Located At 23 OREGON ST

Job ID: 2012-06-4259-ALTR

Jonathan Rioux - Fw: 23 Oregon Street Responses to code items

Because of the extent of renovation, Fire Prevention (I CC'd Capt. Pirone) is going to take a look at the permit. Can you provide a written response vs marking the plans- to the items listed below: The stairwell to the copula would be the only sketch required prior to issuance.

CUPOLA FLOOR PLAN

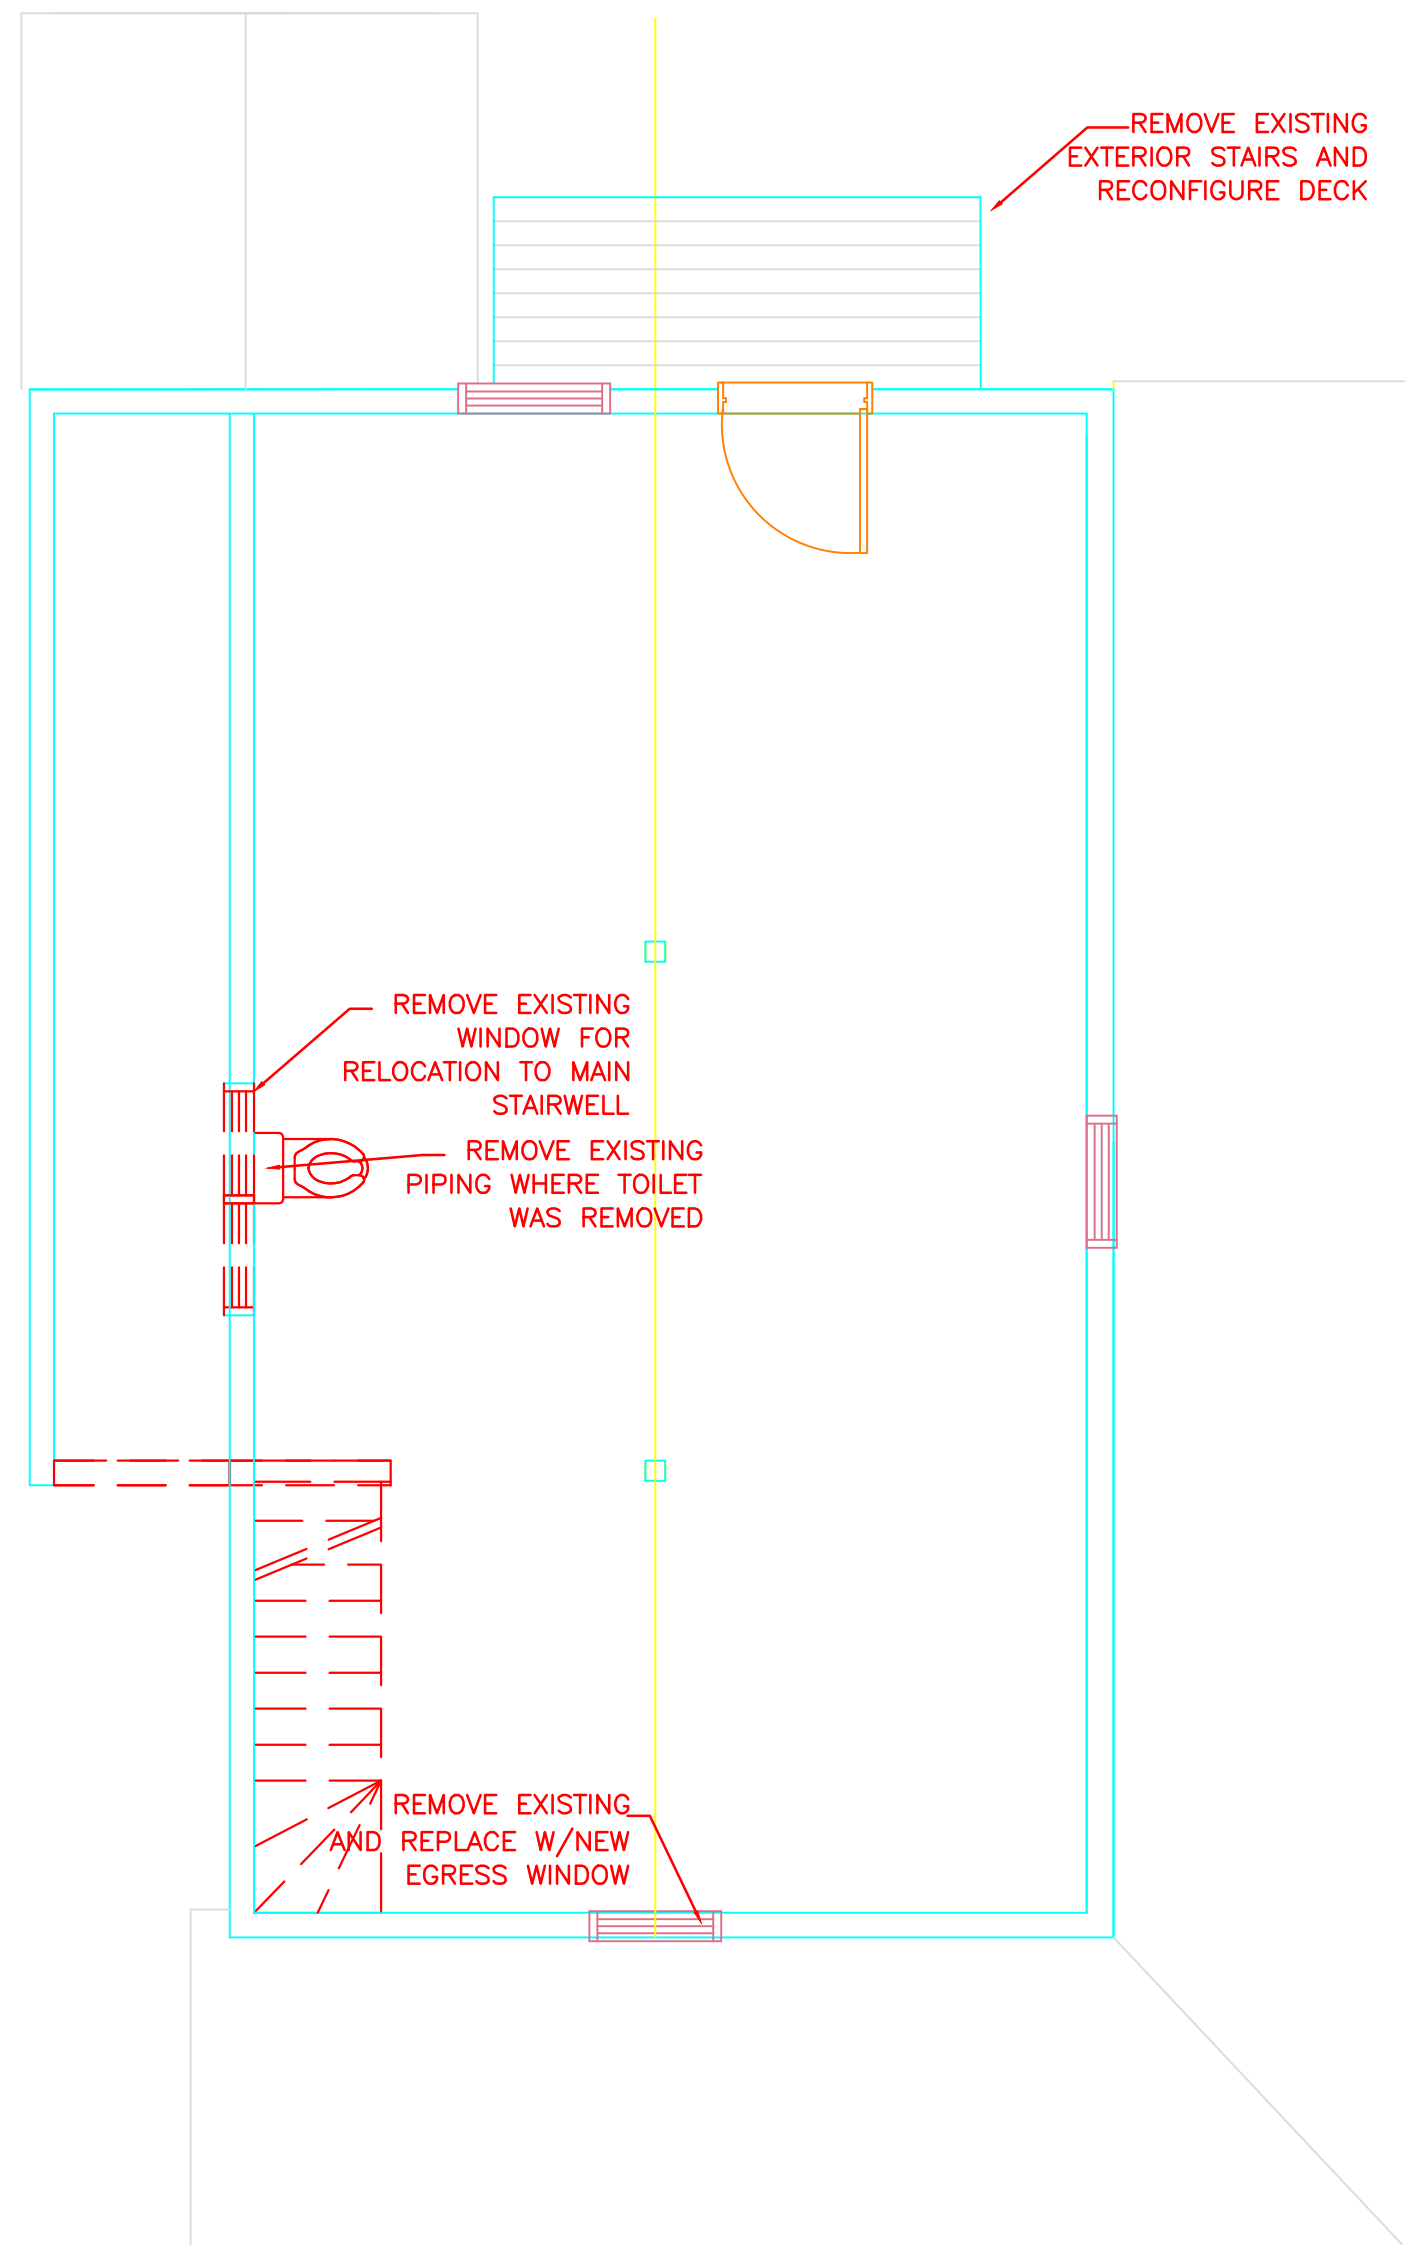
- For our Fire Prevention Bureau- can you indicate if the addition/ renovated area will (or will not) exceed _50_% of the total completed structure?
- I spoke with my Director, the "Cupola" would need a compliant stairwell (she can be reached at 207.874.8703 if you have questions).
